Our ref: DOC22/109891-24

Your ref: SSD-10360337

**Request for advice – St Philip’s Christian College Cessnock Campus – Cessnock LGA**

### St Philip's Christian College Cessnock Campus

PMF Pre-development Peak Flood Level

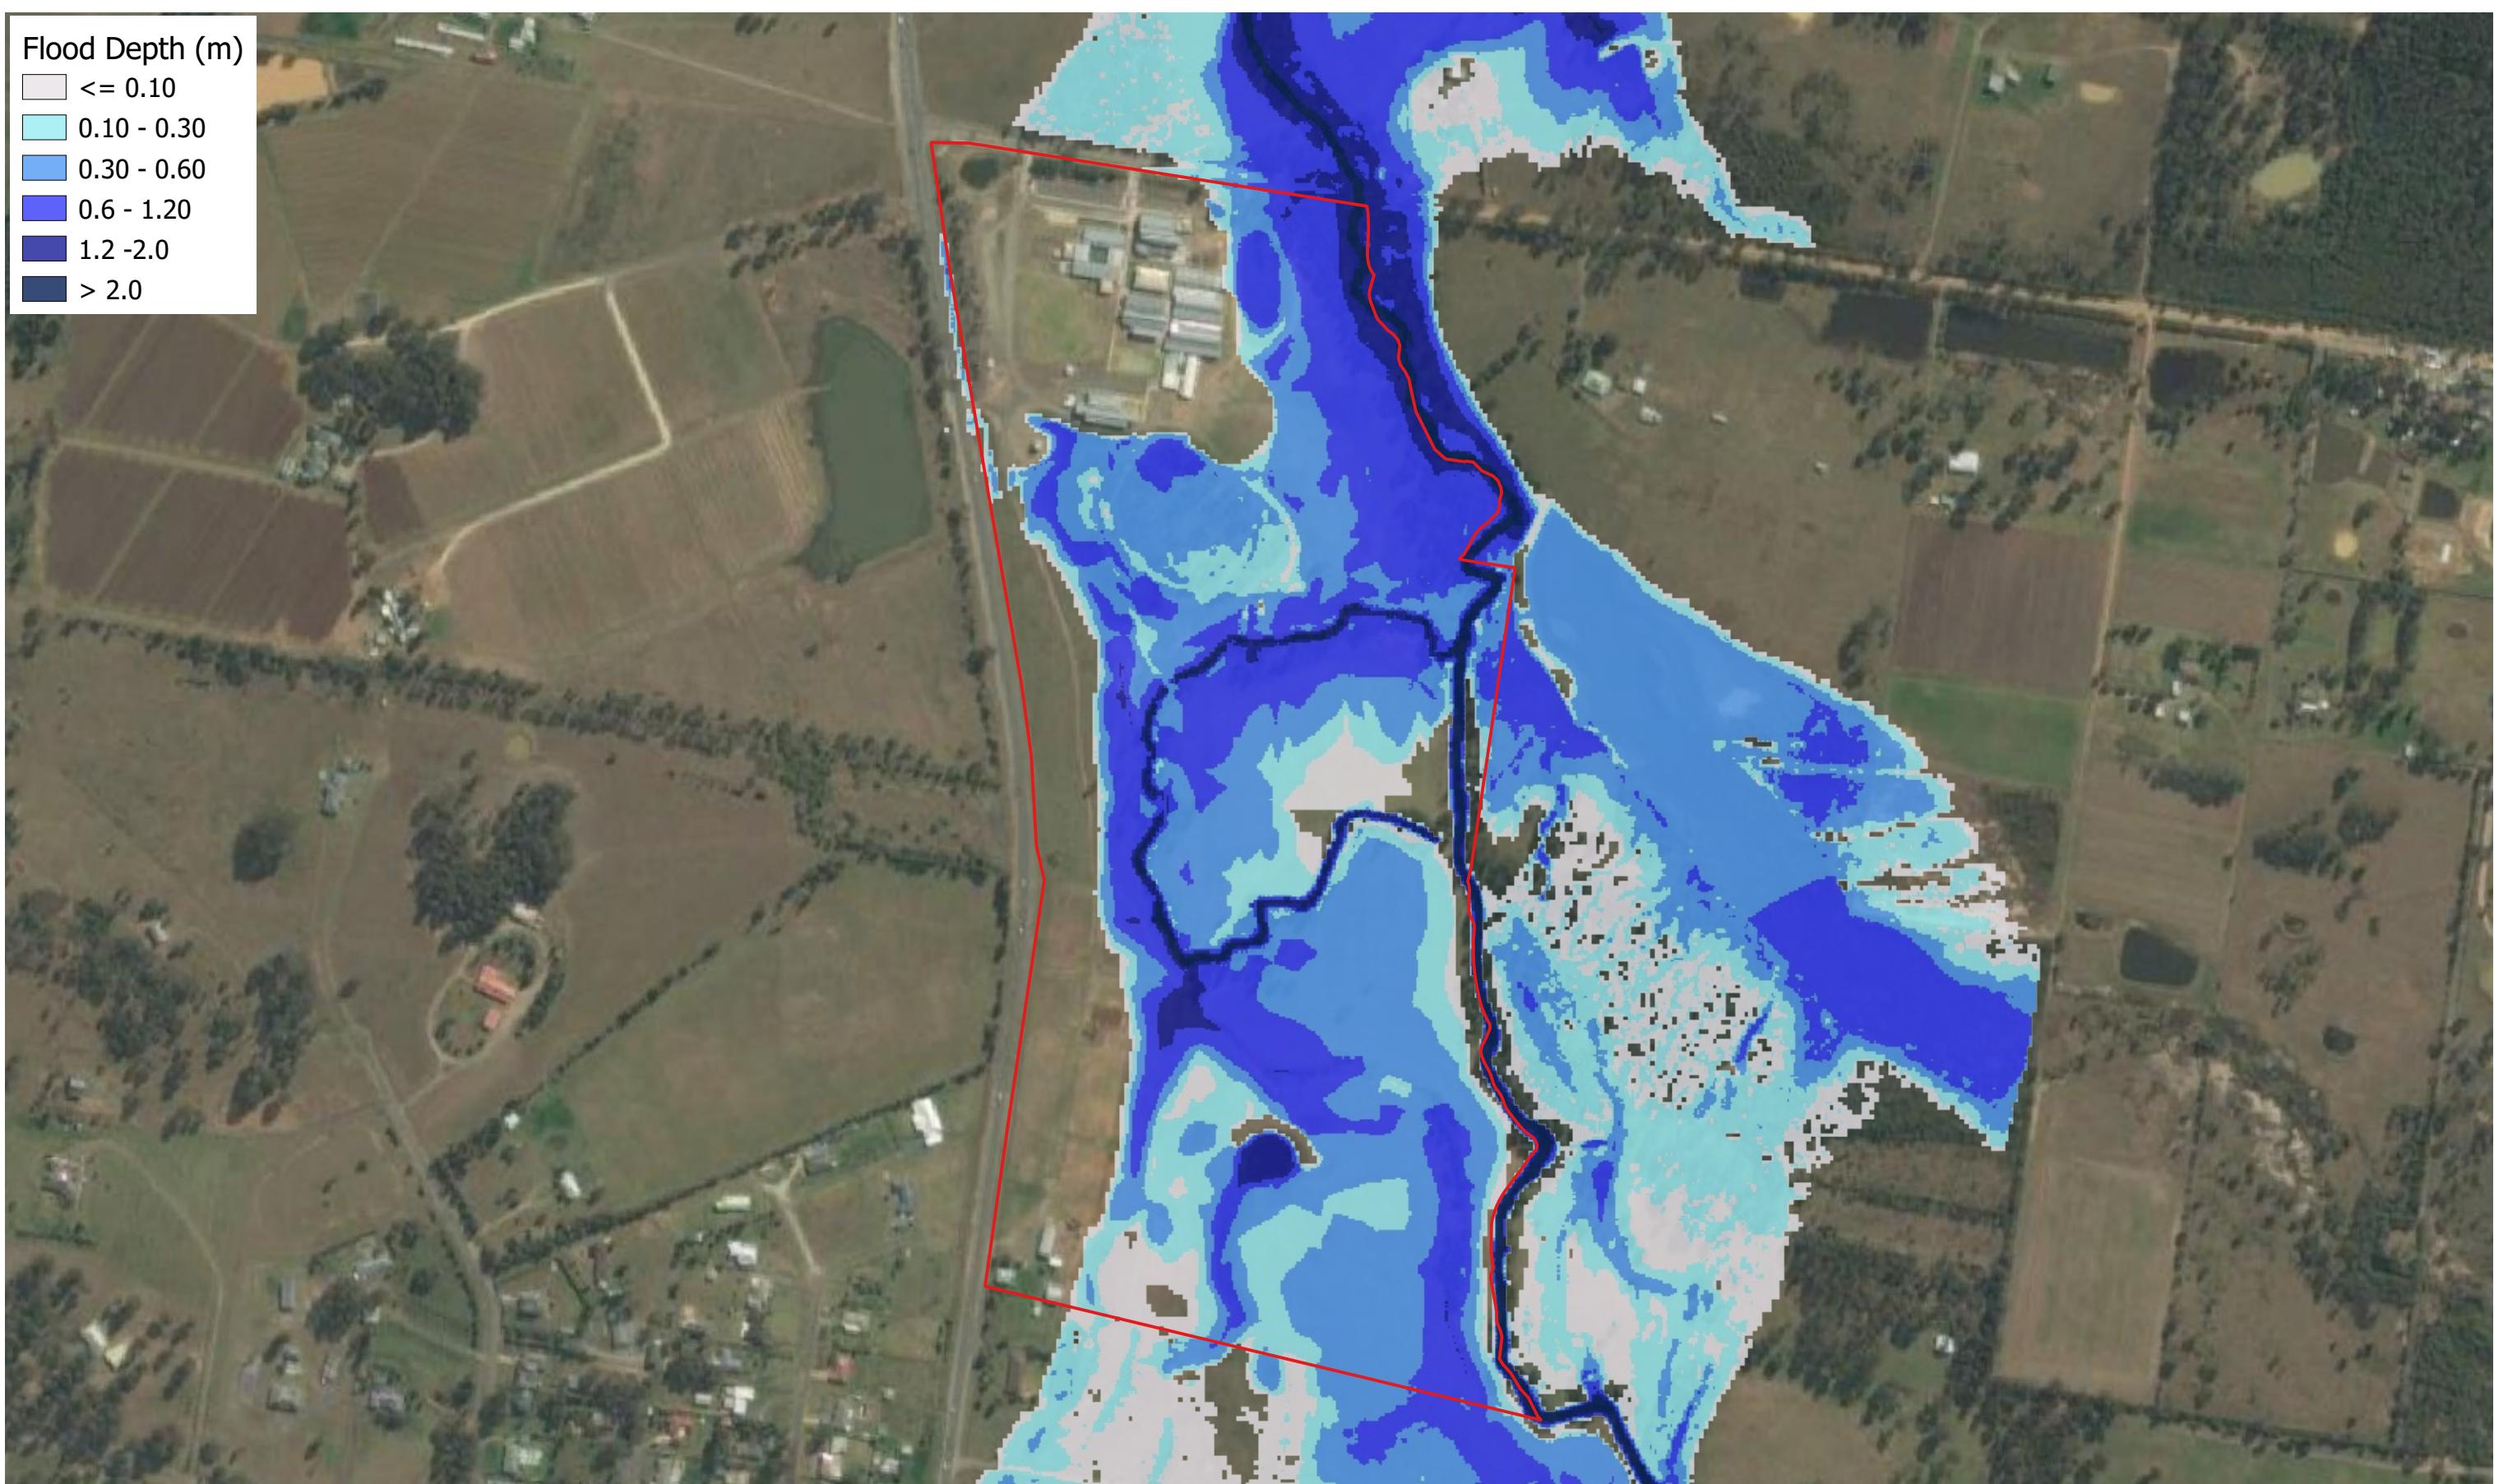
Figures B8 and C8 only have one red colour graduation for the PMF water level, that correlates to > 60.25m. Further information is required for assessing flood risk of the PMF for emergency management and compared with other AEP events for the proposed development / adjacent properties.

BCD recommends that additional colour graduations, above 60.25m are added to Figures B8 and C8 in the flood impact assessment.

Drawing:
D-1

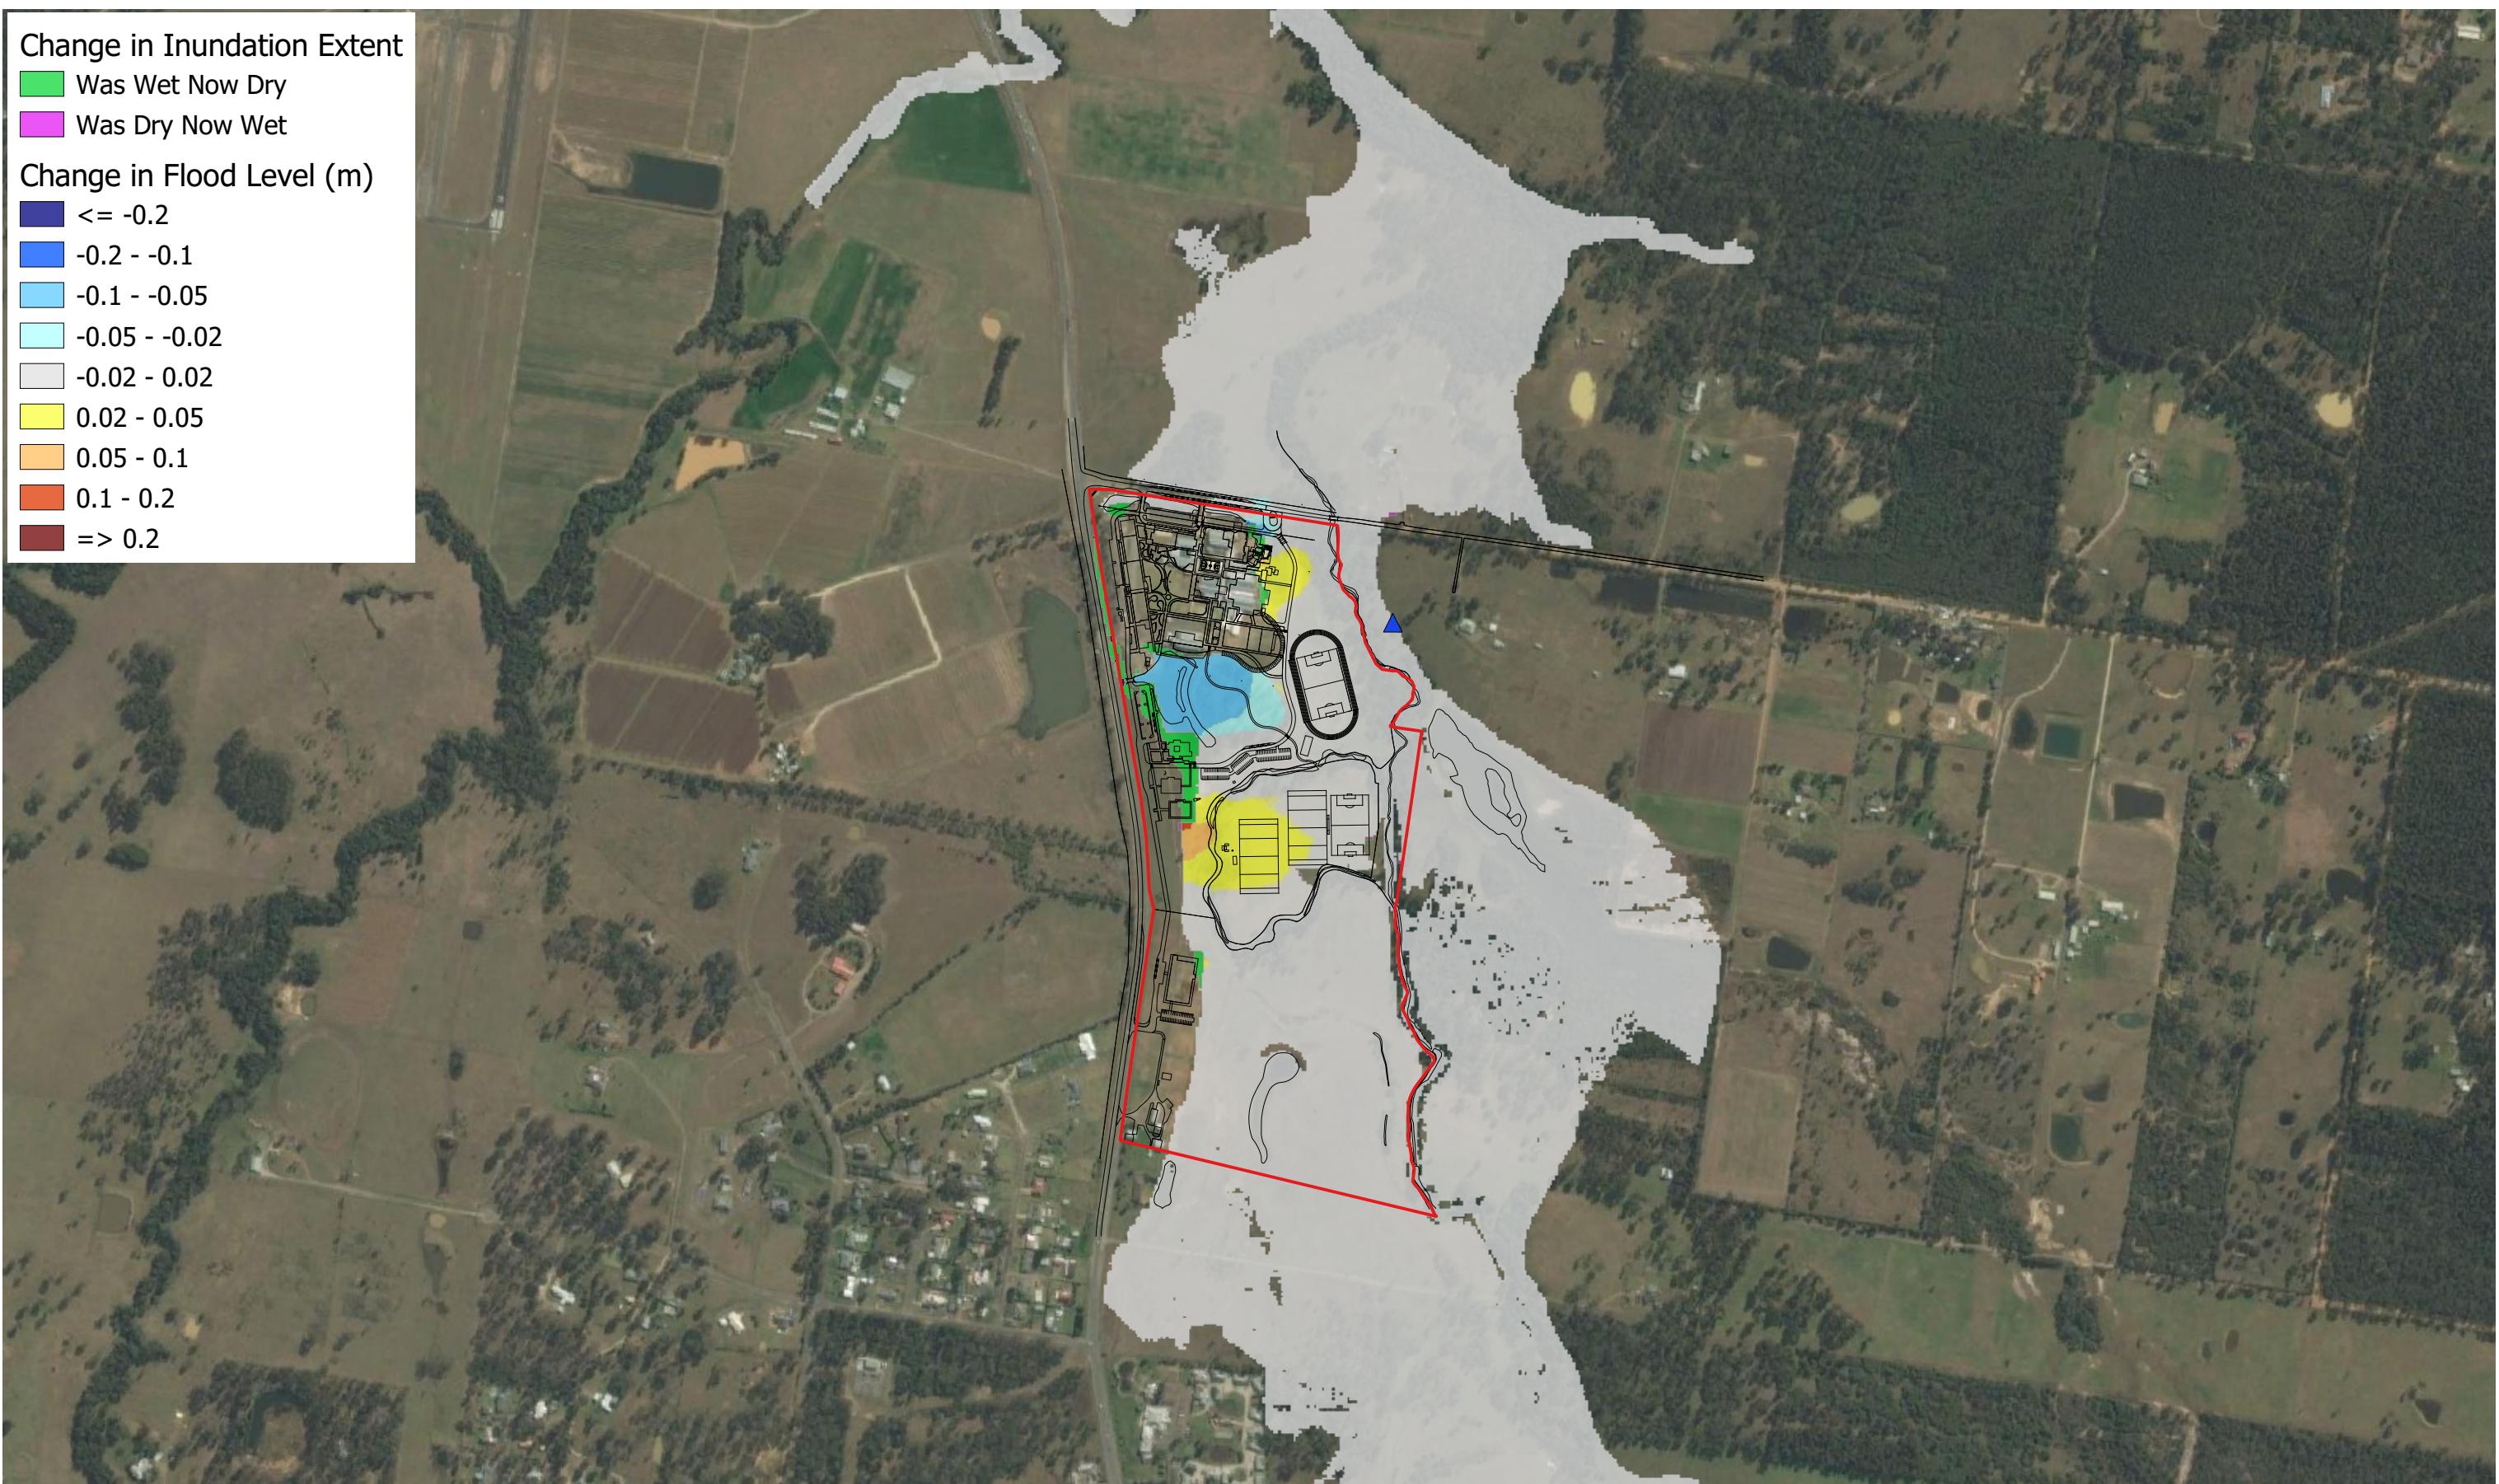
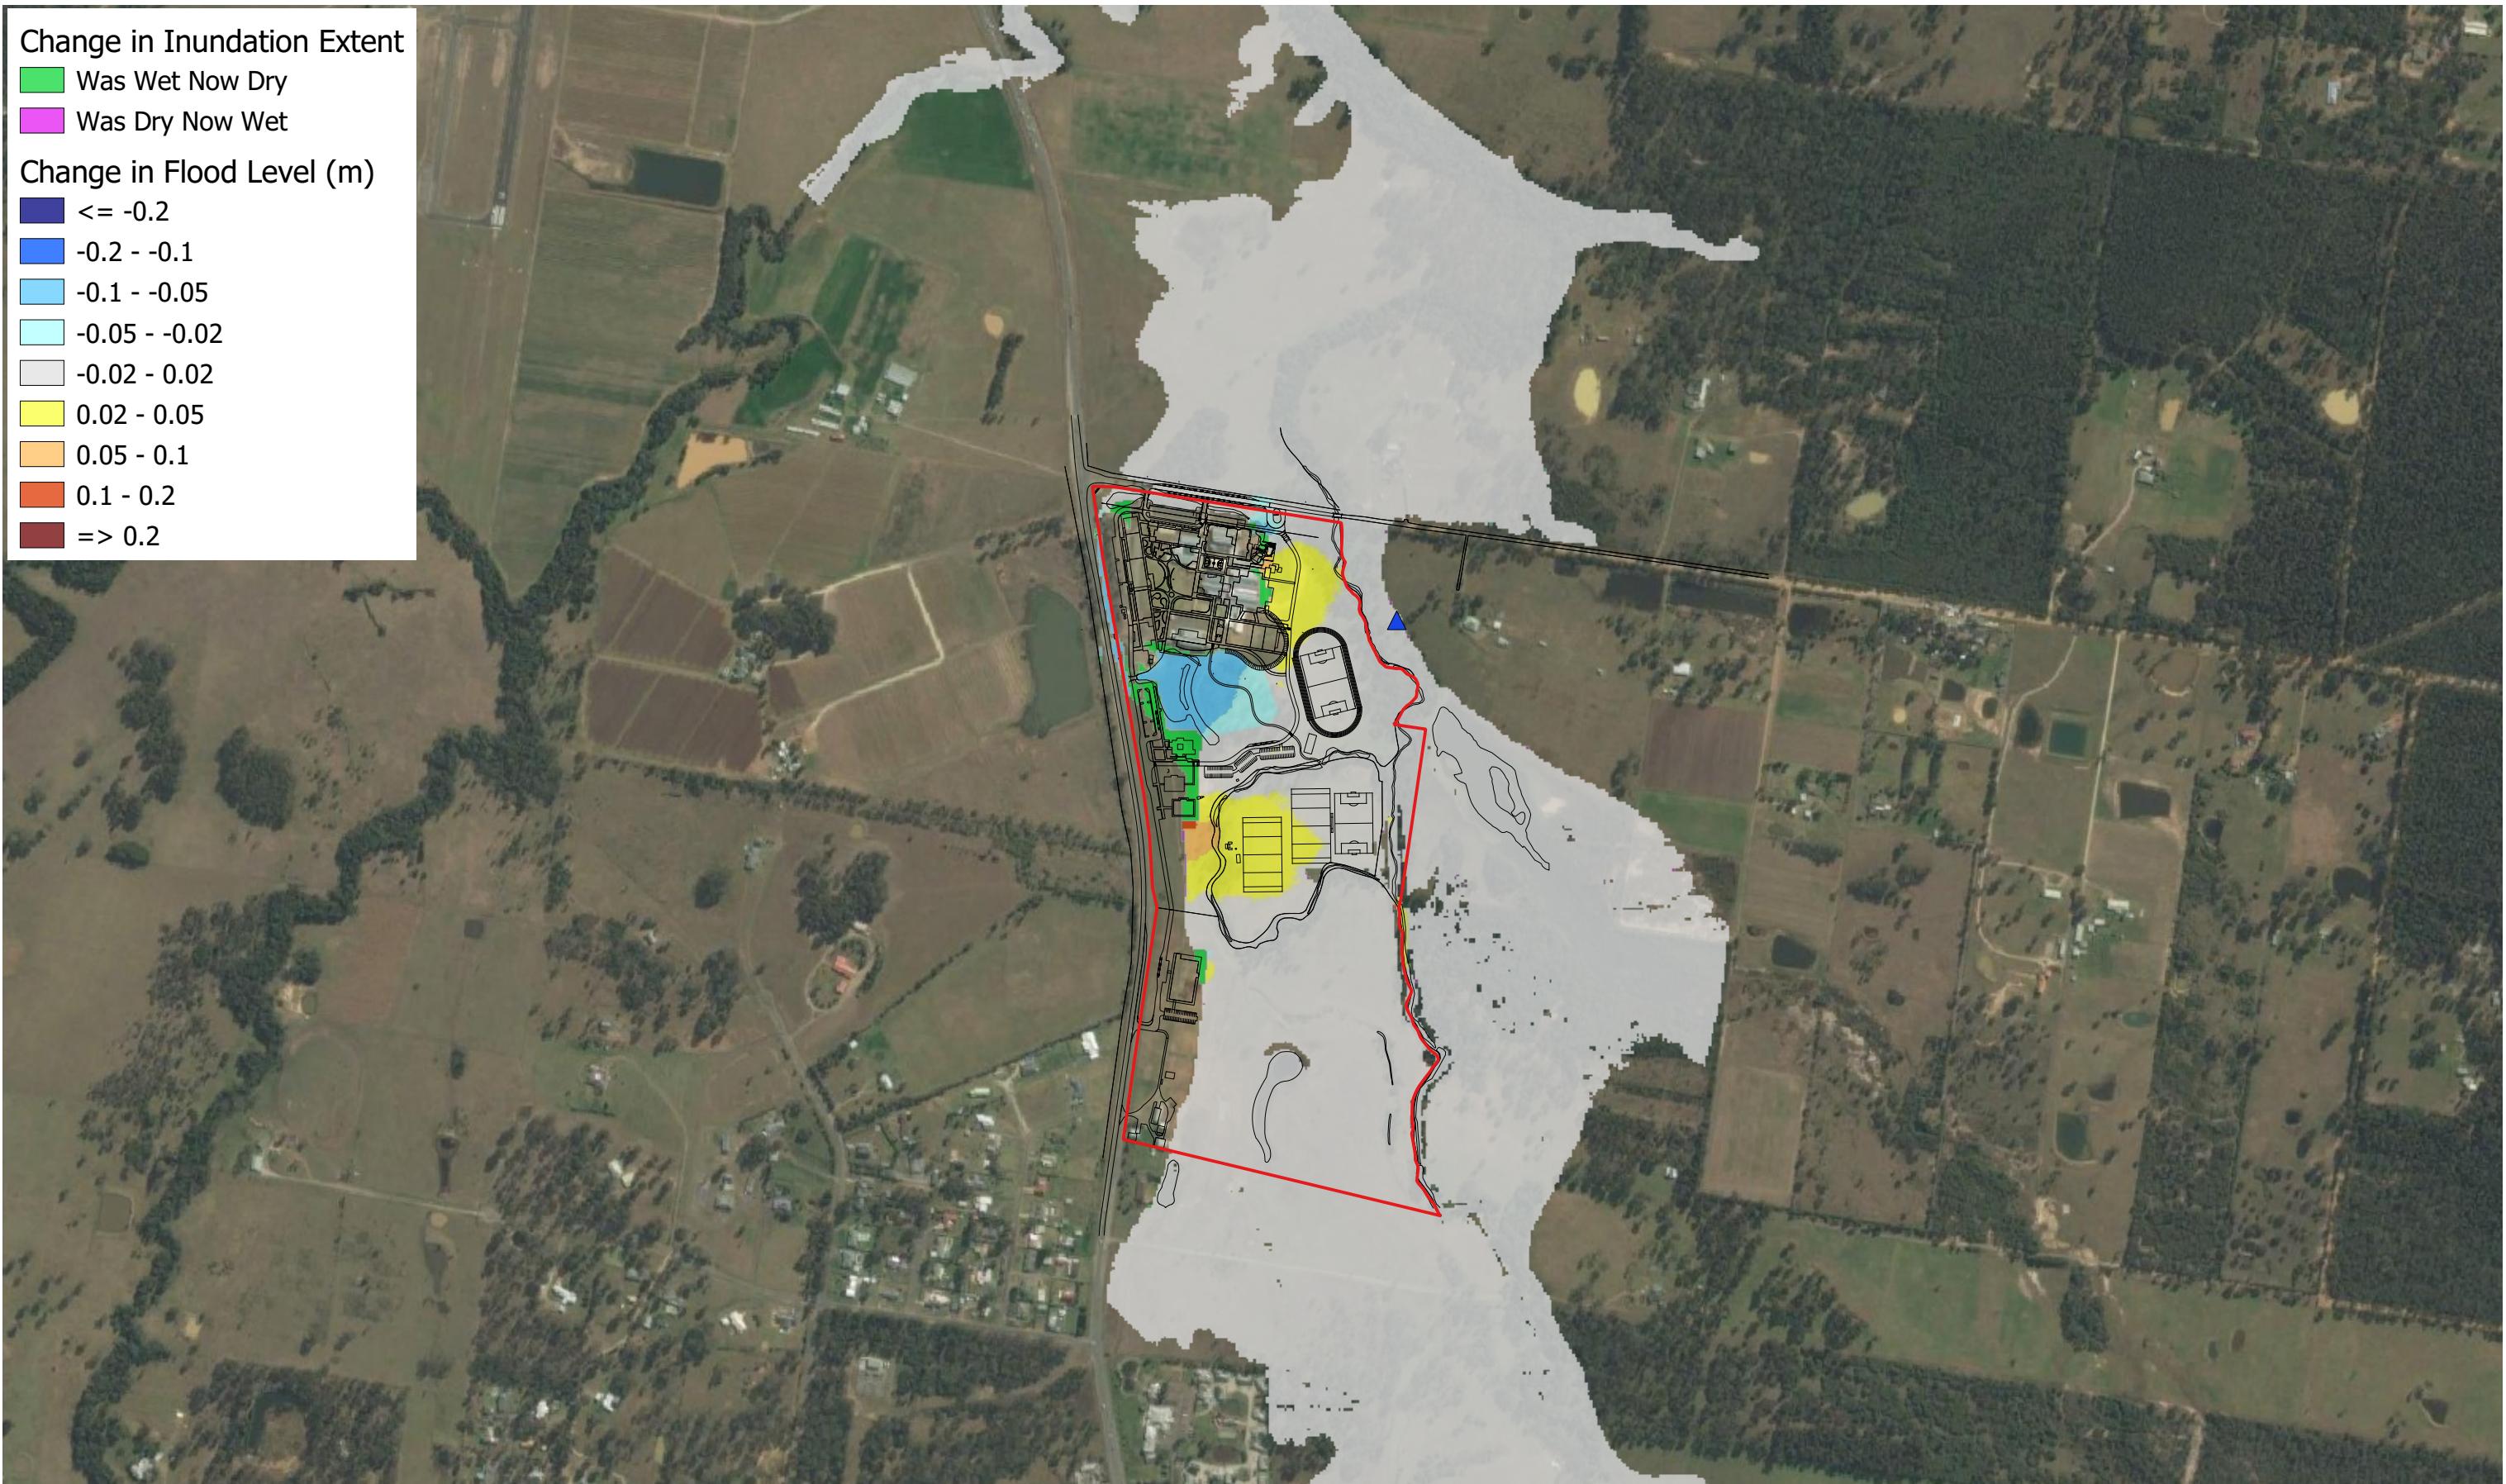
The flood impact assessment currently provides information on the post development impact on peak flood levels (afflux). This is discussed in 5.2.2 of the report and illustrated in figures D1 – D8.

Further information on changes to the following flood risk parameters should be provided to enable BCD to assess any potential impacts:

- peak flood level timings, particularly for the inundation of Lomas Ln. Changes to the timing of inundation of Lomas Lane, in different AEP events, may impact the potential evacuation of the school and other properties on that road.
- impacts on the access to other properties adjacent to Lomas Ln. This would include any changes to AEP events or timings that the accessways become inundated and un-trafficable.

BCD advises that the proponent provide further information as to the flood risk, including any changes to the timing of the inundation of Lomas Ln and any accessways to properties from that road.
